Arroyo Vista Apartments: 4201 Bryn Mawr Dr NE

Re: Drainage Ordinance (14-5-2-1) Violations for Erosion and Sediment Control

Stabilized Construction Entrance/Exit

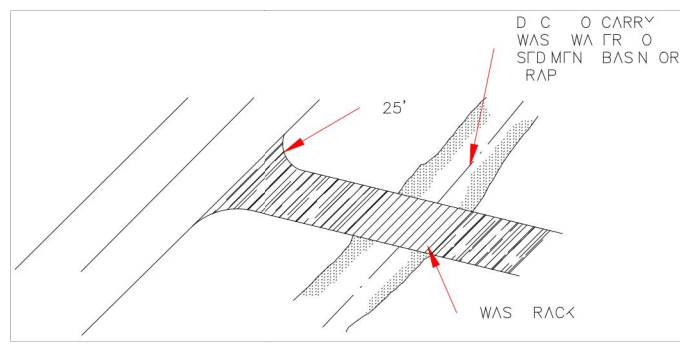
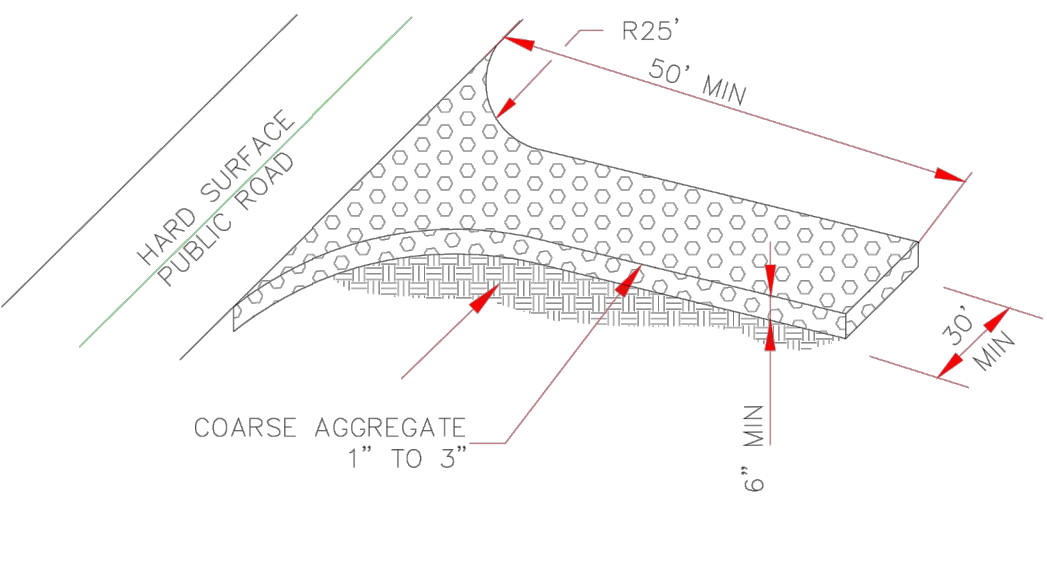
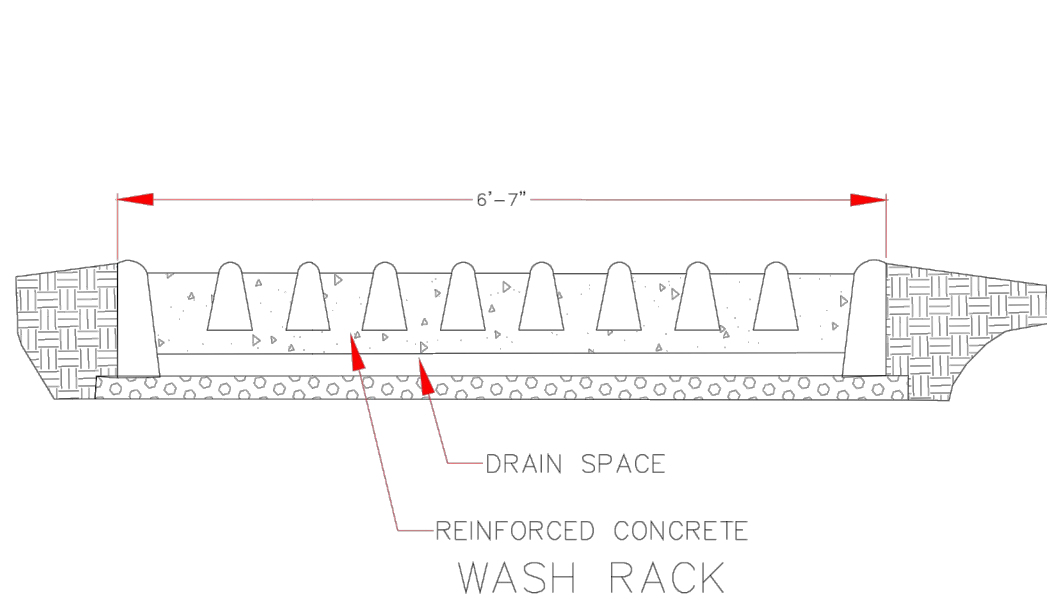
1. Track-out pad/stabilized construction entrance requires maintenance.
2. Sediment in private drive, Pathway Ave and Vassar Dr.
3. Sediment on sidewalk on Pathway Ave and private drive from sweeping.

Track-out pad requires maintenance/reinstallation.

1. Remove sediment from street and gutters from the project to the trees shown in the End of removal photo (last photo).
2. Remove sediment from sidewalk on Pathway Ave and private drive. Private drive is located between this site and Pathway Ave.
3. Track-out pad shall be maintained to prevent track-out. The length may need to be extended.
4. Since sediment in the street was also observed on 5-23-17, install inlet protection on the inlet on the north side of Pathway Ave just east of Vassar Dr. Since this is a cattle-guard inlet, the entire inlet does not require protection just the grate and throat near the gutter.
